Question No. (Ref No.)	Question
1.1.8	<p>In Table 7.1 of the ES [APP-049] Redcar and Cleveland Borough Council (RCBC) identified that Dormanstown air monitoring station had seen some 1 hour NOx 'spike' concentrations.</p> <p>Why do you consider that this might have occurred and what effect would it have on nitrogen dioxide (NO2)?</p> <p>RCBC indicated a spike of up to 200ug/m3 whilst the applicant indicated 93.7. Why is there such a difference?</p>

Figure F2.1 Operational Noise Contours - One Train

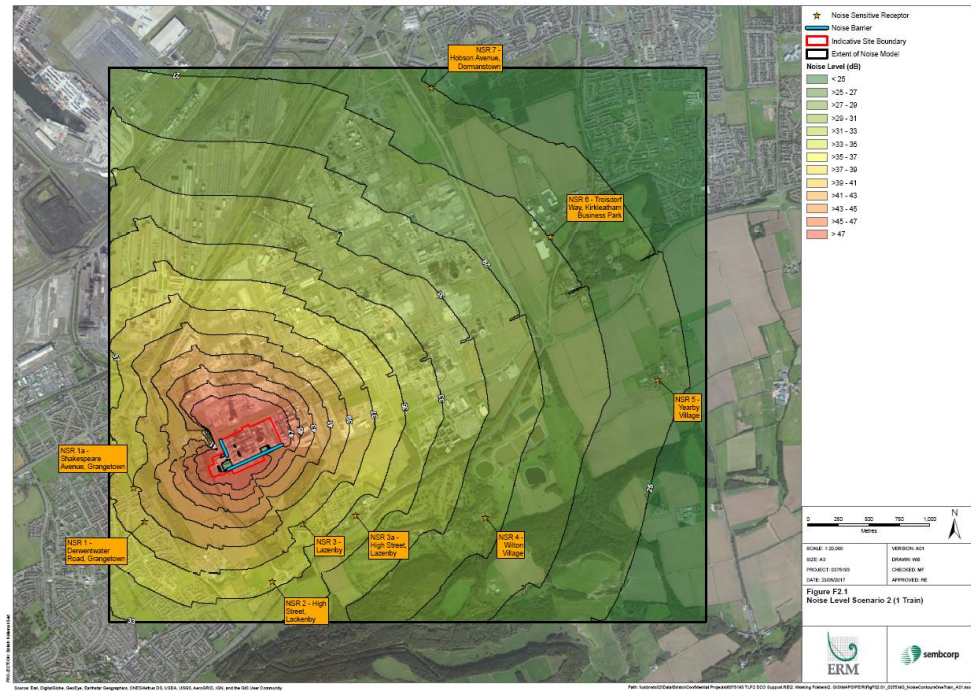
1.9.14	<p>In paragraph F1.3 of Annex F2 [APP-072] it is stated that it is not appropriate to combine operational and construction noise levels in Scenario 2.</p> <p>Explain further why this is the case and specifically, why it would not be possible to use the operation of the first train as the future baseline and then assess construction noise impacts of the second train?</p>

Figure I2.3 *Vehicle Parking*

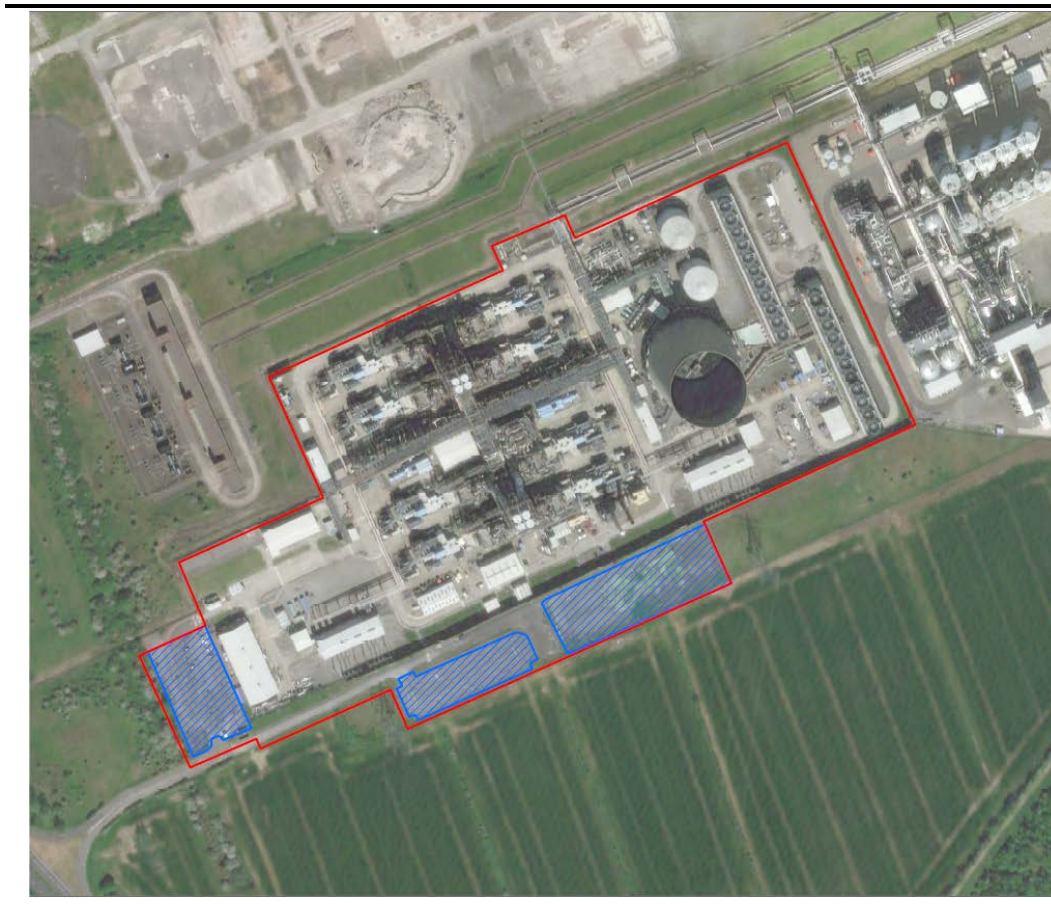
1.5.14	<p>Paragraph L16 of Annex L [APP-081] states that the size of the parking provision together with access and egress routes will be set out in the final CEMP. Paragraph L21 also indicates that designated routes for HGV movements and construction workers car movements will be provided in the CEMP.</p> <p>Are the Council content to leave these matters for later determination or should they be included in the framework CEMP based on material within the Transport Assessment [APP-077]?</p>

Figure 11.5 Local Landscape Character Areas

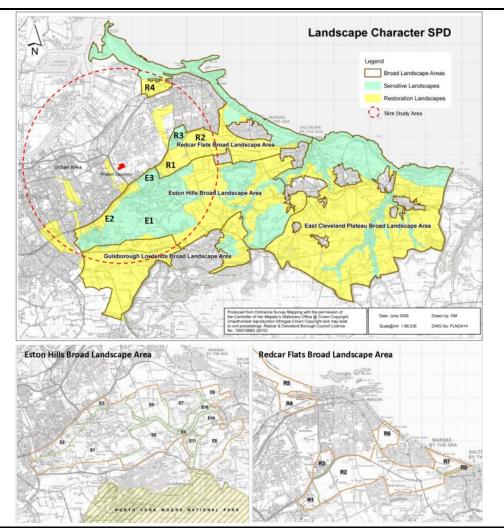
1.8.6	<p>Figure 11.4 of the ES [APP-053] shows the Local Landscape Character Areas with the project location being within the urban area and not within any defined Local Landscape Character Area.</p> <p>Whilst not formally characterised, what is the local character of the area within which the Project is located?</p> <p>There does not appear to be a conclusion of the likely significant effects on the National Character Areas (NCA), although paragraph 11.34 of the ES [APP-053] states that NCA 25 would be largely unaffected due to topographical screening. On what basis was it decided not to assess the effects on NCA?</p>

**Figure 6.5 - Landscaping Proposals**

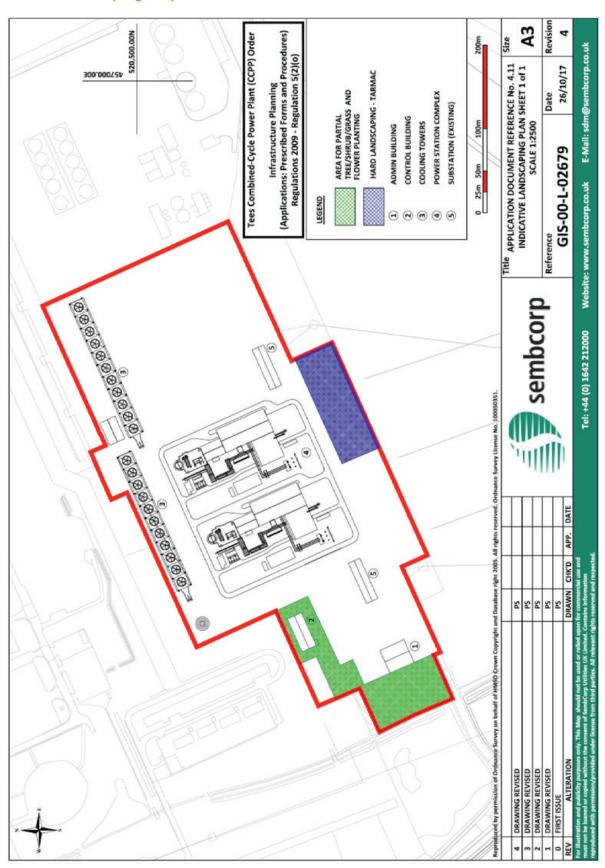
1.8.18	<p>Indicative Landscaping Plan [APP-029] shows an area for partial tree/shrub/grass and flower planting to the west of the site.</p> <p>Would it be appropriate to introduce similar soft landscaping within the areas reserved for Carbon Capture and Storage to the east of the site in the period until that scheme is brought forward? If not, why not?</p> <p>Why is the area to the south of the site identified for hard landscaping – tarmac rather than soft landscaping?</p>
